## REQUEST

Current Zoning: ML-2 (manufacturing and logistics, 2)  
Proposed Zoning: MUDD-O (mixed-use development, optional)

Approximately 0.96 acres located at the southeast intersection of Thrift Road and Jay Street, north of Freedom Drive.

Staff recommends approval of this petition upon resolution of requested technical revisions related to site design.

PROJECT: LUCKY DOG BARK AND BREW- 2220 THRIFT ROAD CHARLOTTE, NC 28205
 PETITIONER: LUCKY DOG CHARLOTTE PROPERTY, LLC
 15928 HENRY LANE HUNTERSVILLE, NC 28078
 SHEET TITLE: EXISTING CONDITIONS CONDITIONAL SITE PLAN
 SHEET: L1 OF 1

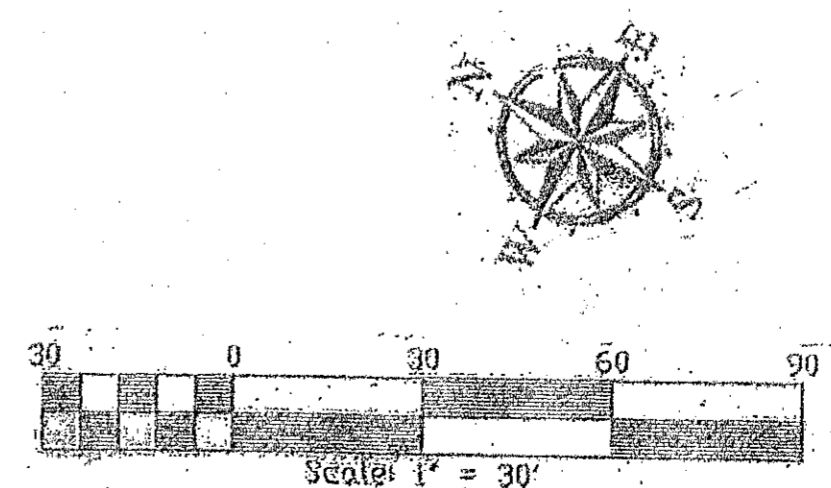
1. Include the minimum number of parking spaces that would typically be required on the site without the optional provision in addition to the listed number of parking spaces that will be provided with the optional provision.
-
